DRB CASE ACTION LOG - BLUE SHEET

Project #: 1002202 Application #: 12DRB-70106
 Project Name: Winrock Center Addition
 Agent: Huitt-Zollars Inc. Phone #:

To: Jack Cloud, DRB Chair
From: Christopher Hyer, Senior Planner 
RE: Winrock Town Center, Phase 2 Development

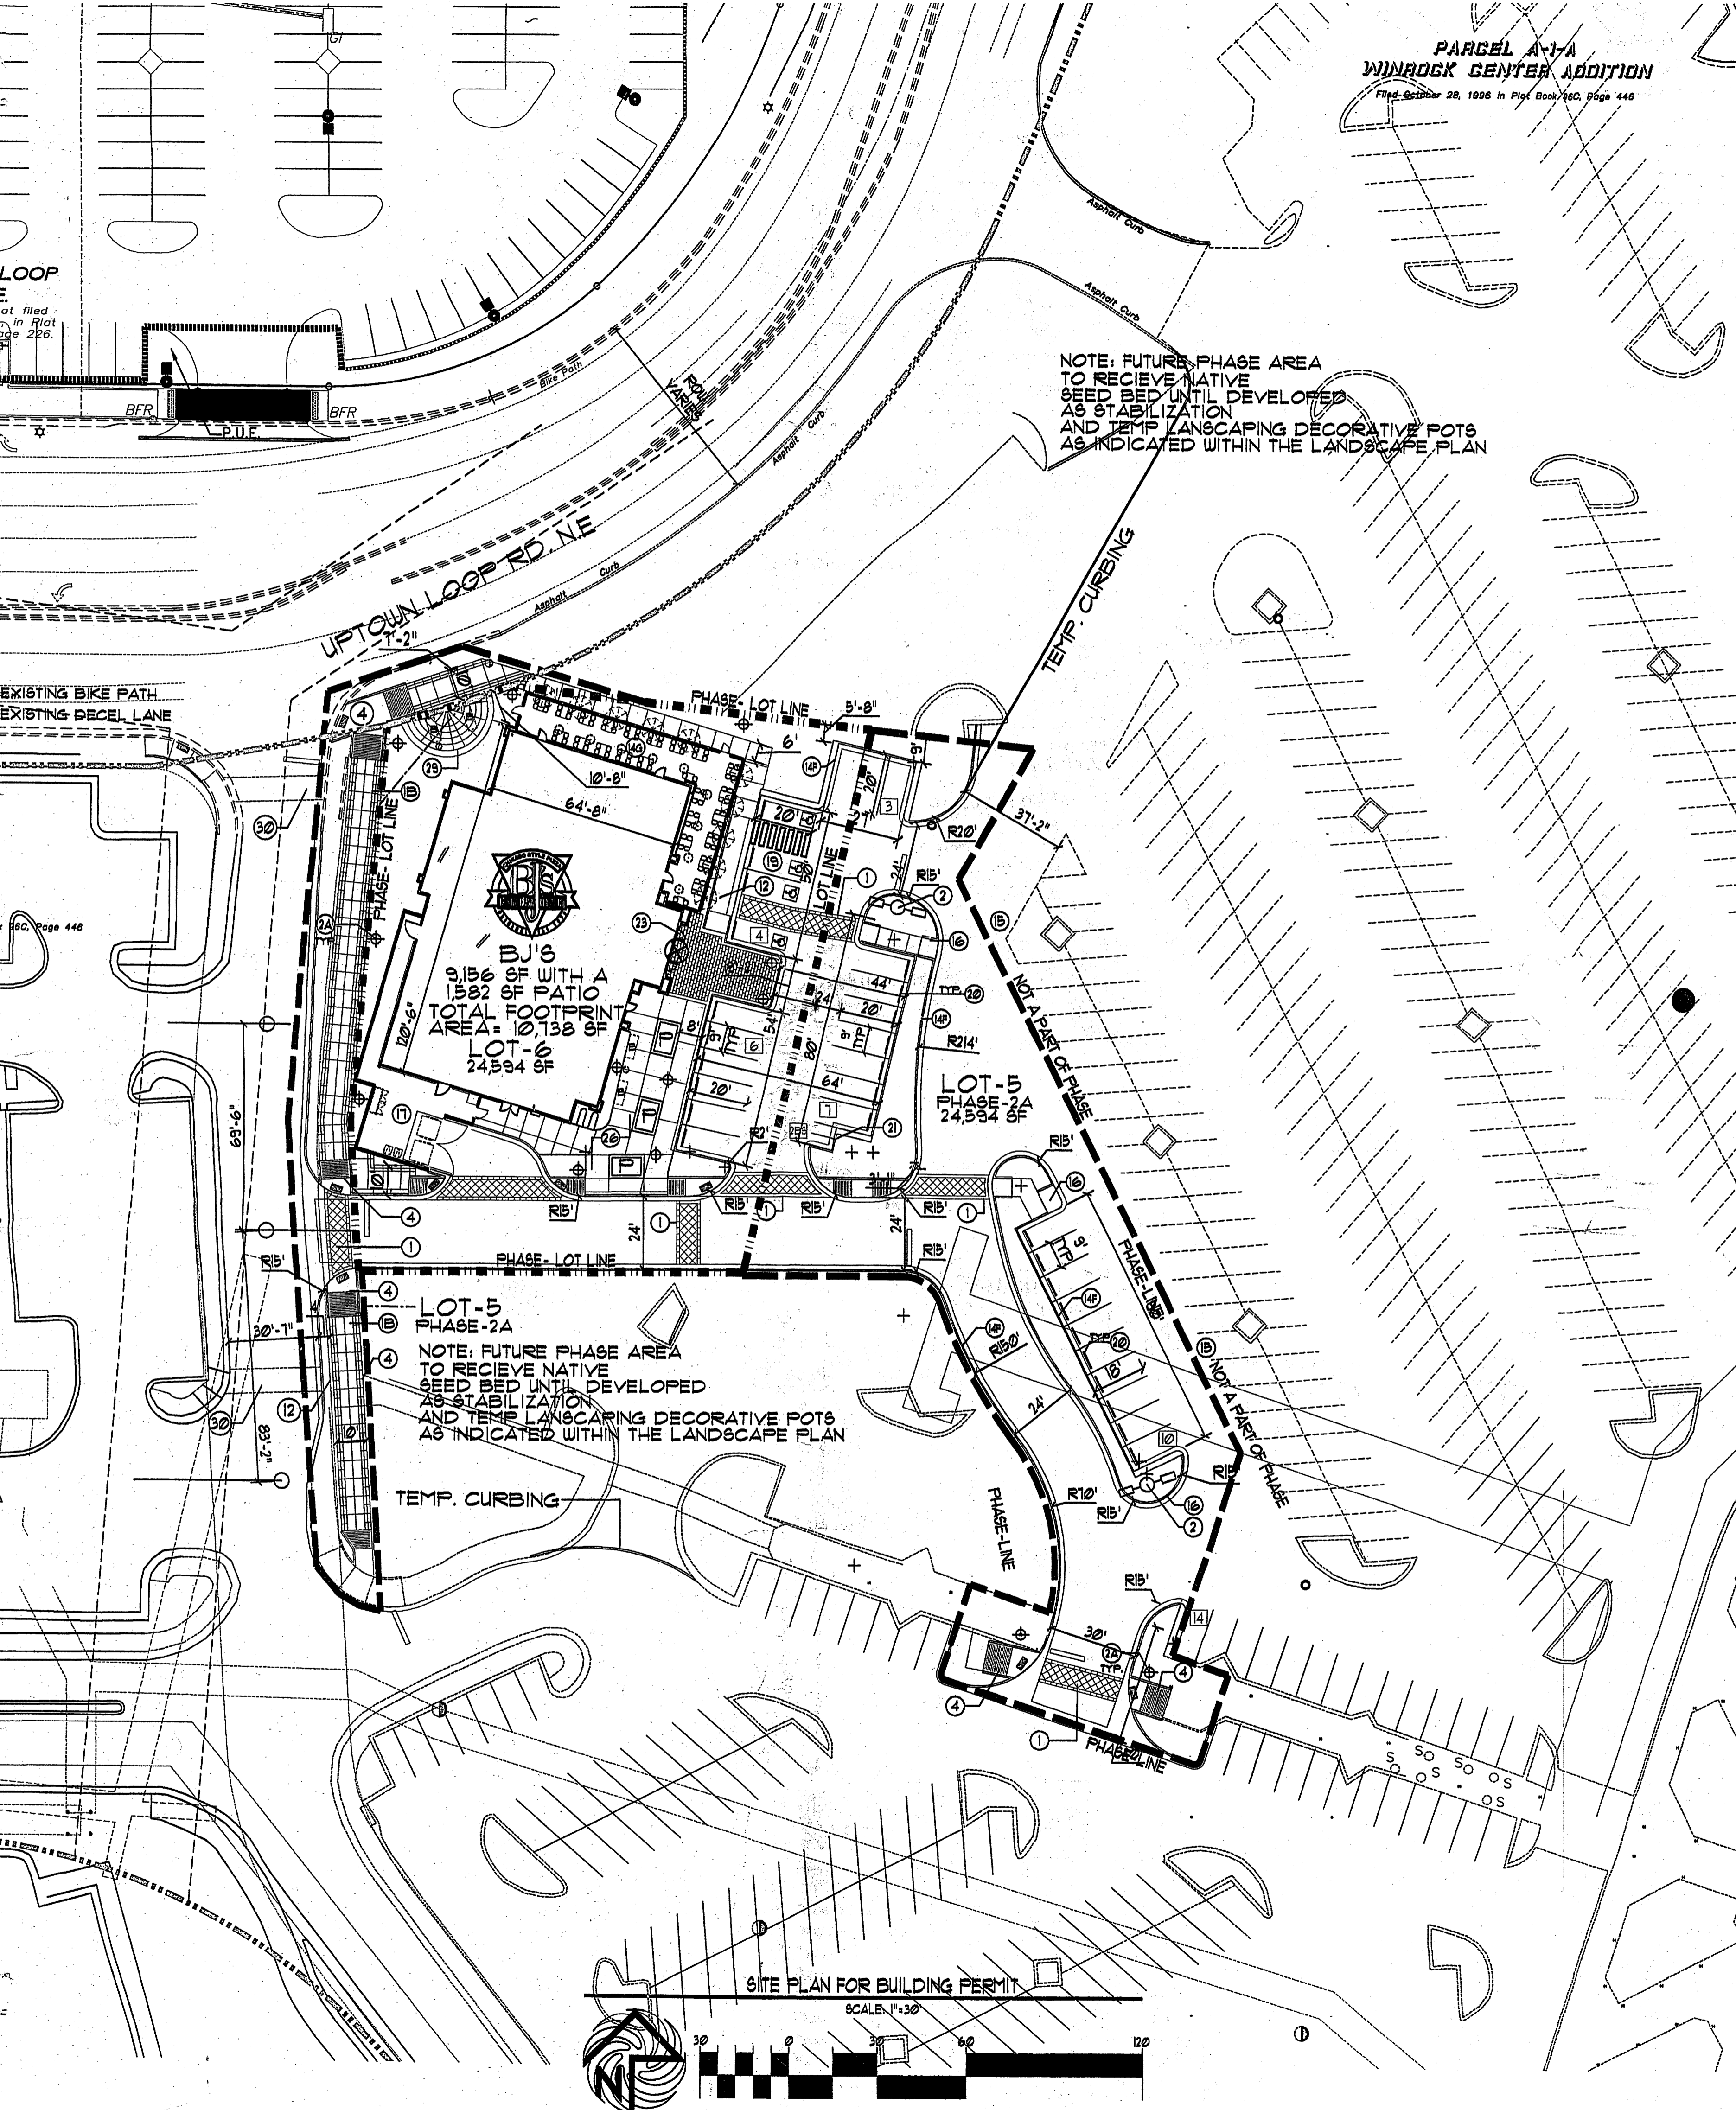
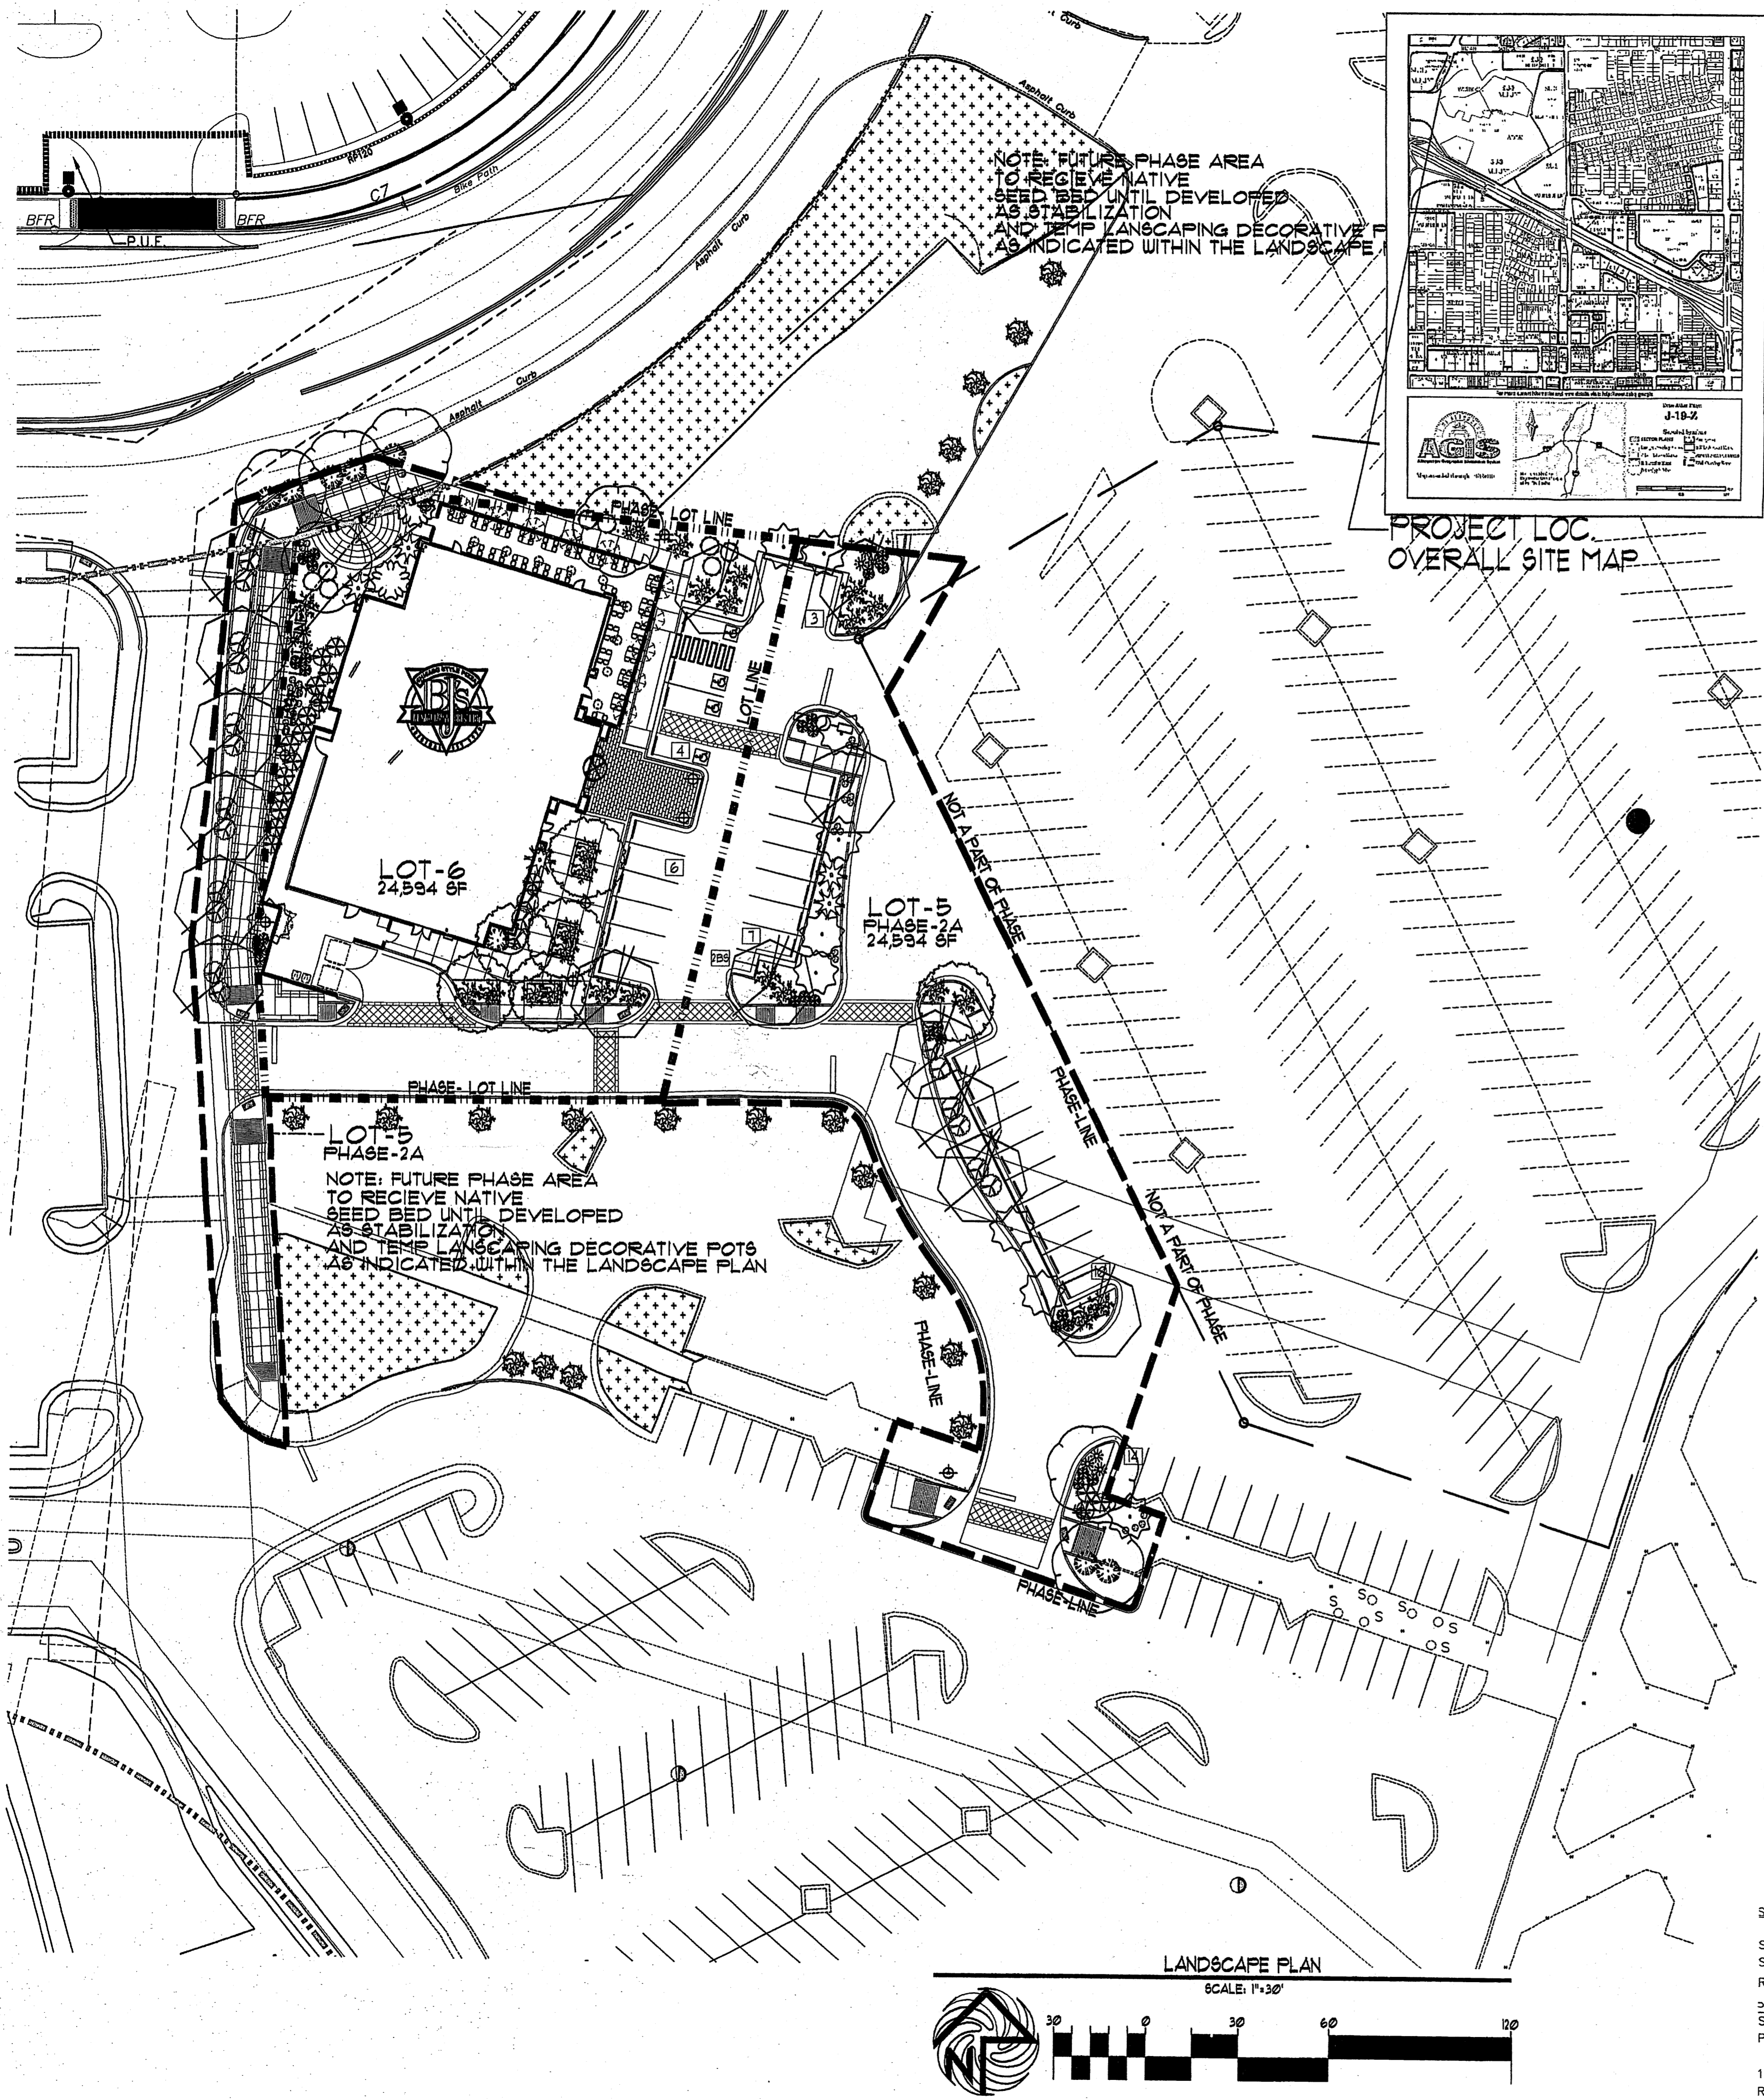
PLANNING (Last to sign): OK Revise Ped crossing; Interim Landscape Plan; 15 day appeal period
